Your Ref: MP 08_0255 MOD 3 and CP 08_0255 MOD 3

Development: **Modification Requests for Elf Mushroom Farm and Substrate Plant**

Property Details: **Lot 13 & 14 in DP 1138749
No. 108 & 112 Mulgrave Road MULGRAVE NSW 2756**

Figure 1

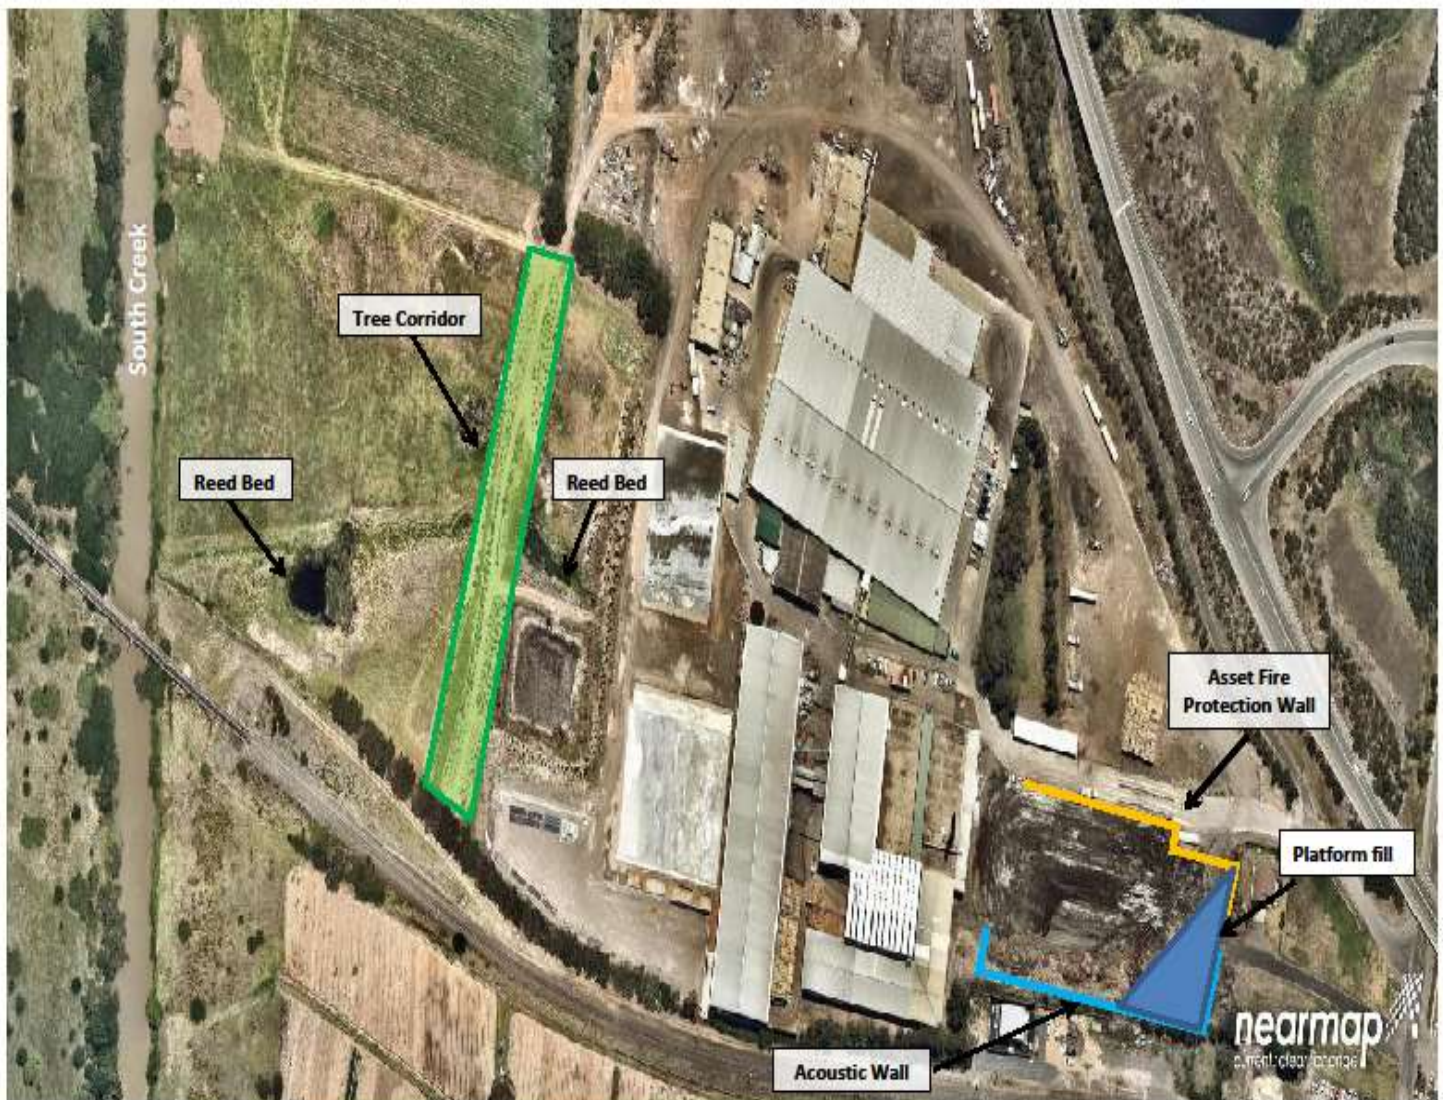
Council does not generally support the importation of fill material into the floodplain. Whilst it is acknowledged that the flood assessment provided confirms that the loss of flood storage volume would be minimal it is considered that filling in the floodplain should not be viewed in isolation.

Any proposal to import material within a floodplain should take into account incremental encroachment into the flood liable land, gradual loss of flood storage volume in the basin, and potential increased risk to the community, property and public infrastructure.

It is recommended that any earthworks associated with the bale storage area and tree corridor be modified so that it does not rely on the need to import any material into the floodplain.

**PROPOSED SOUND WALL
ELEVATIONS AND SECTION**

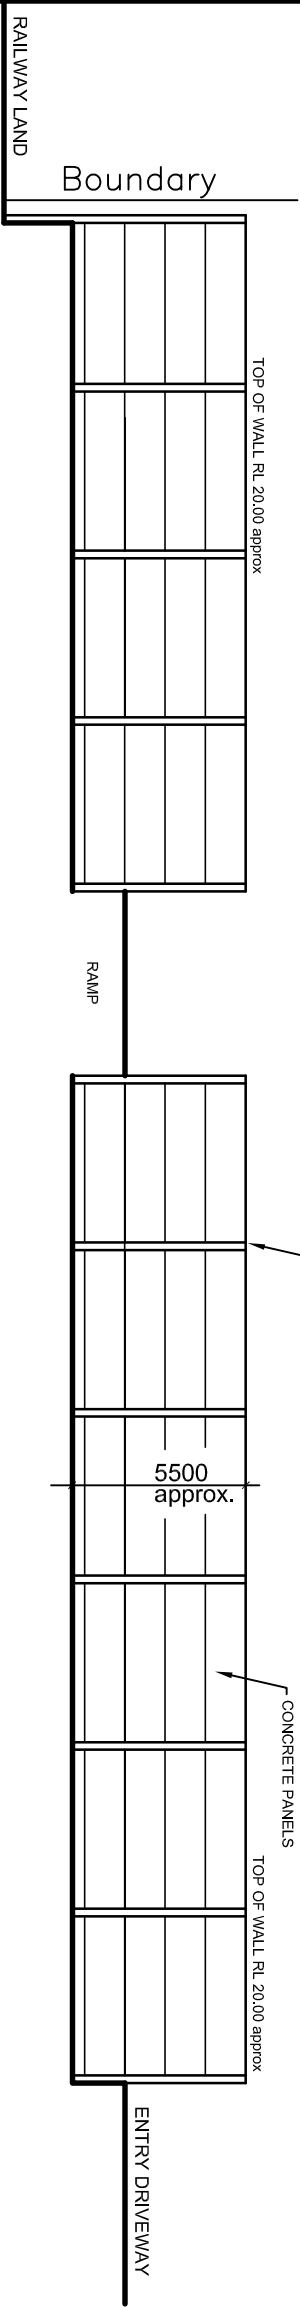
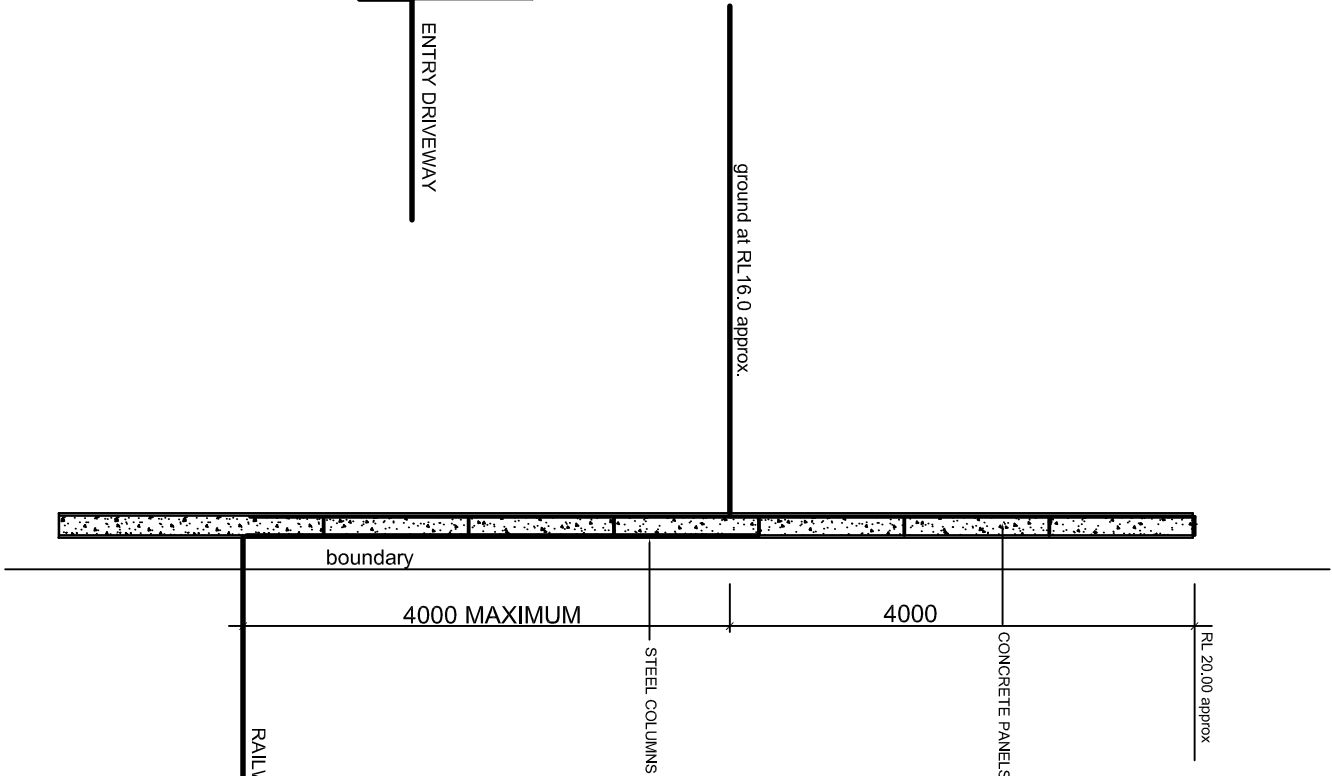
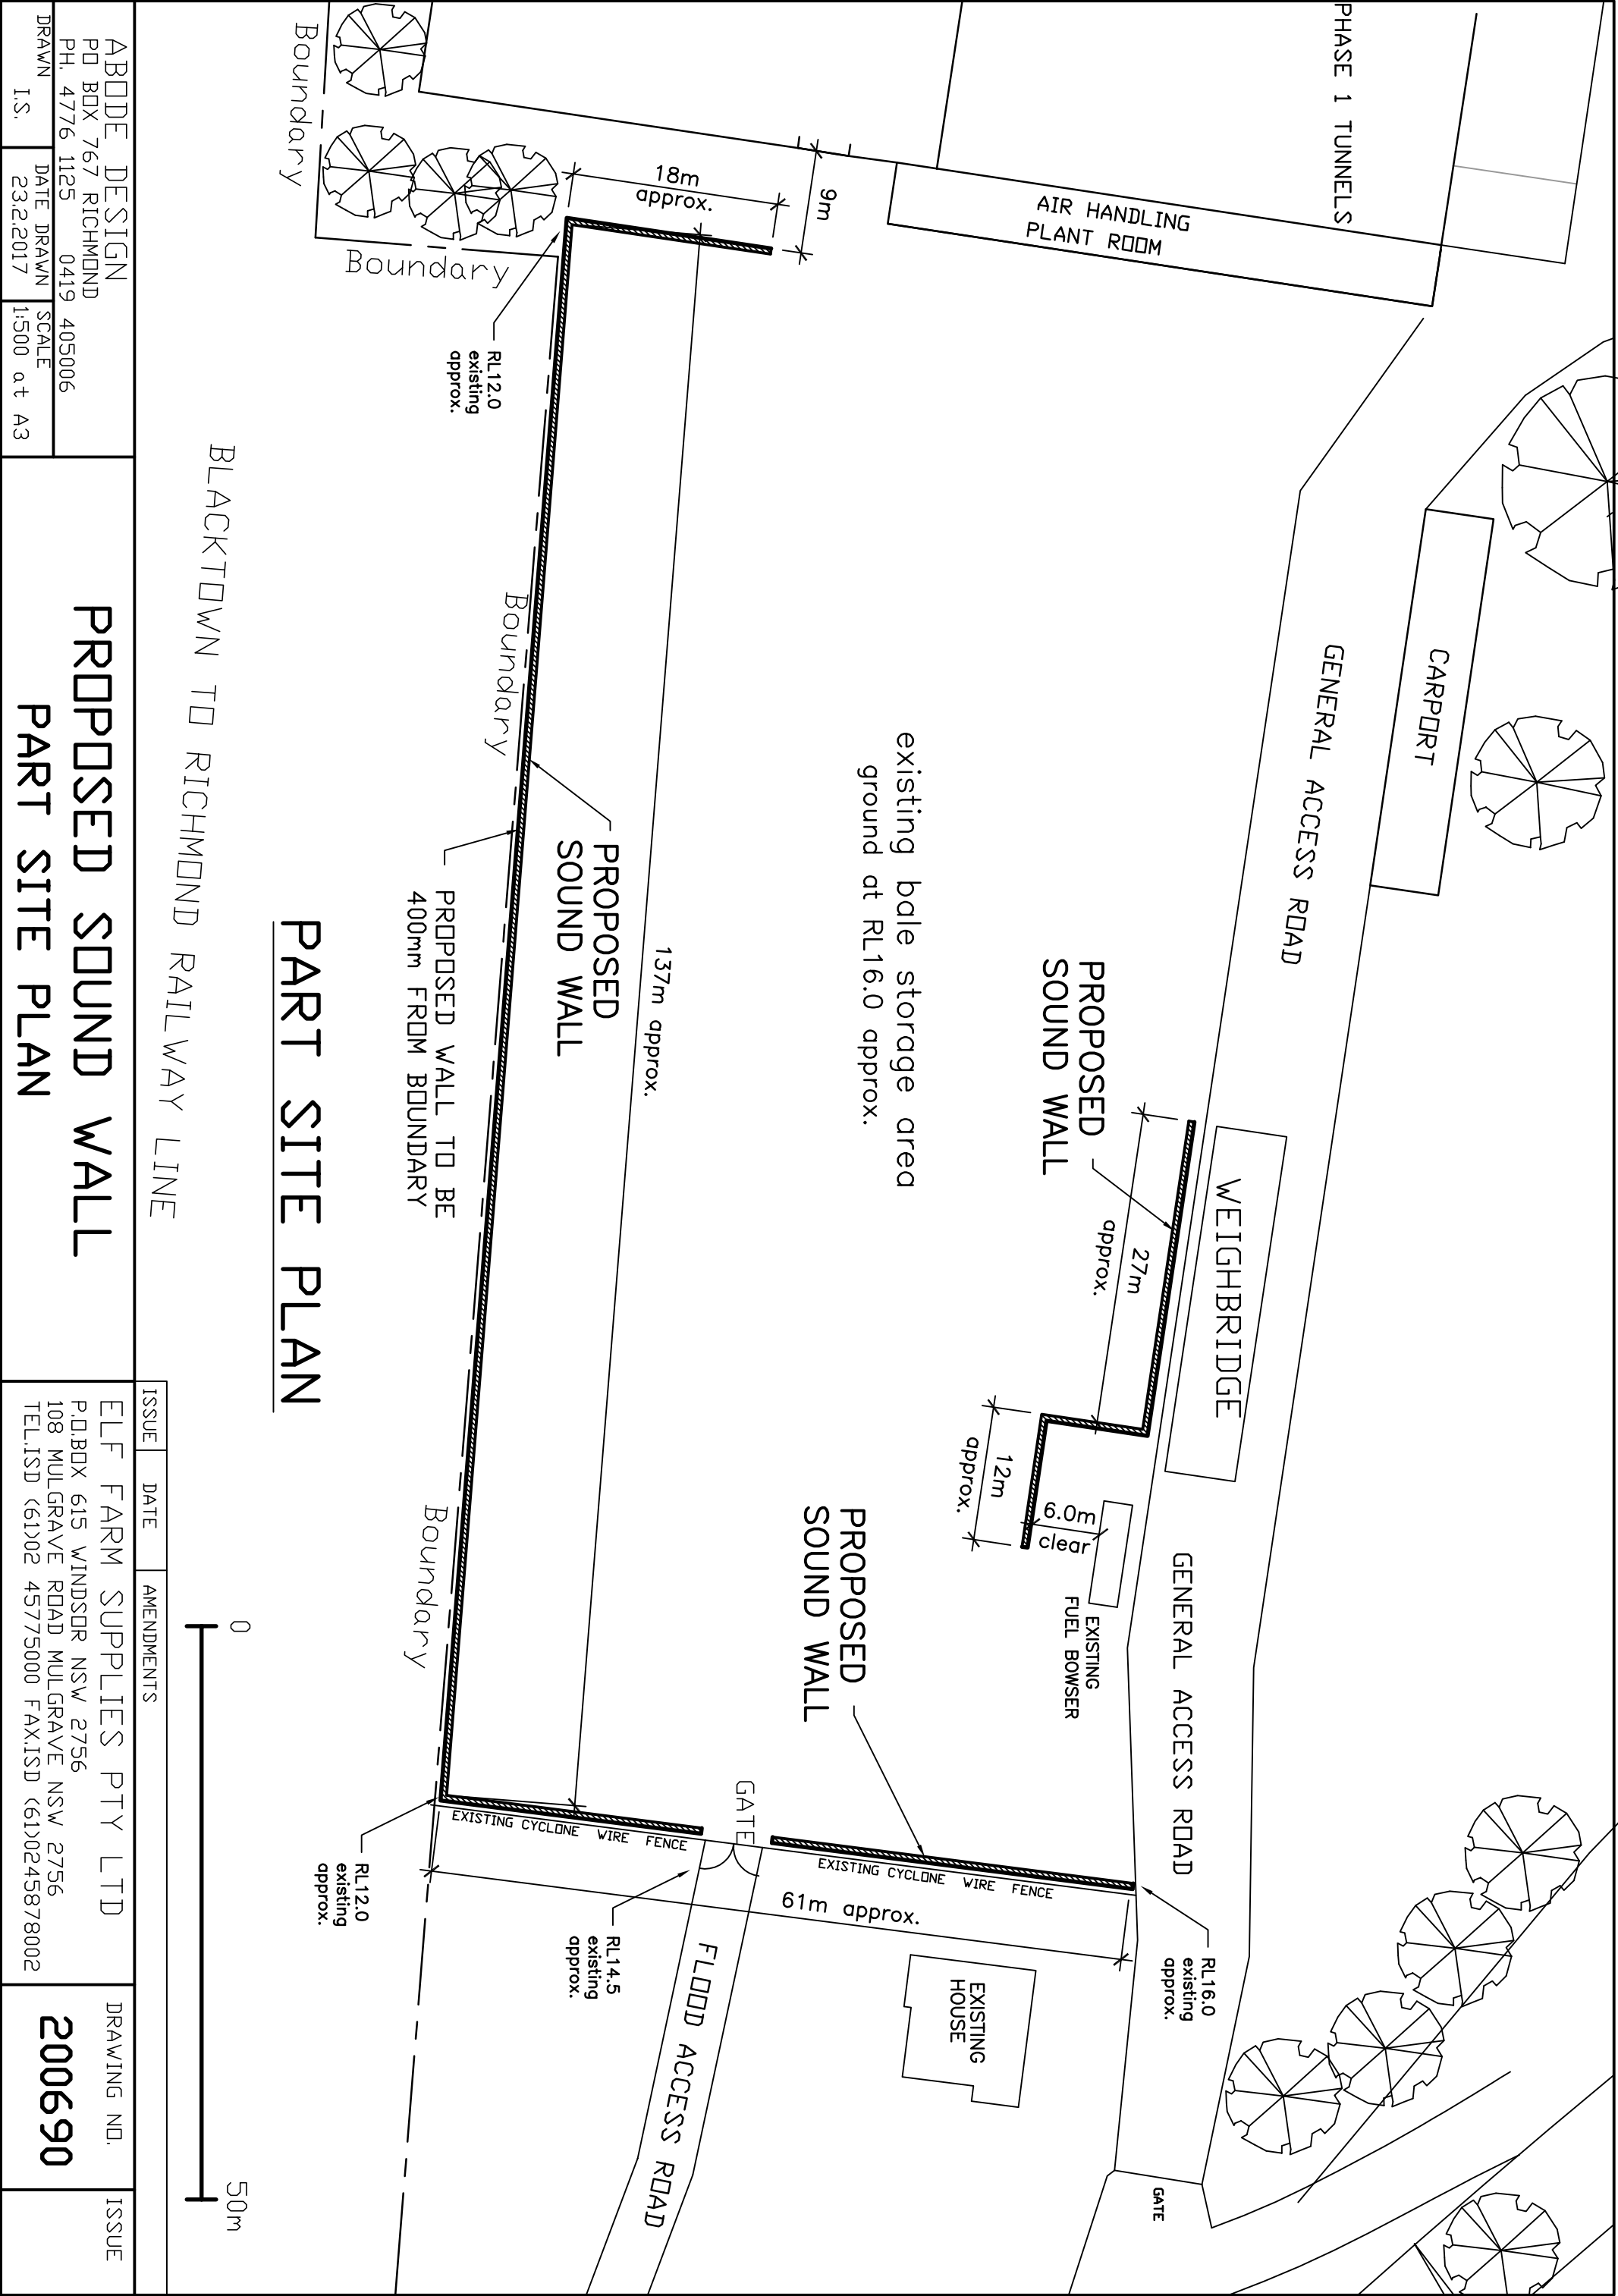
The application must address the visual impact the proposal would have on the overall appearance of the locality and on adjoining land uses. Currently it is unclear as to the colours or material treatment proposed to be used on the retaining walls and concrete panels proposed along property boundaries.

It is considered appropriate that landscaping be provided between the new walls and property boundaries consistent with existing landscaping provided around the site. Existing landscaping should be incorporated into any new landscape plan.

Details need to be provided demonstrating that the retaining wall and concrete panels along property boundaries can be accessed for maintenance. It is unclear as to whether or not the proposed setback would be able to accommodate sufficient room to access the walls in order to address matters such as graffiti removal or repainting.
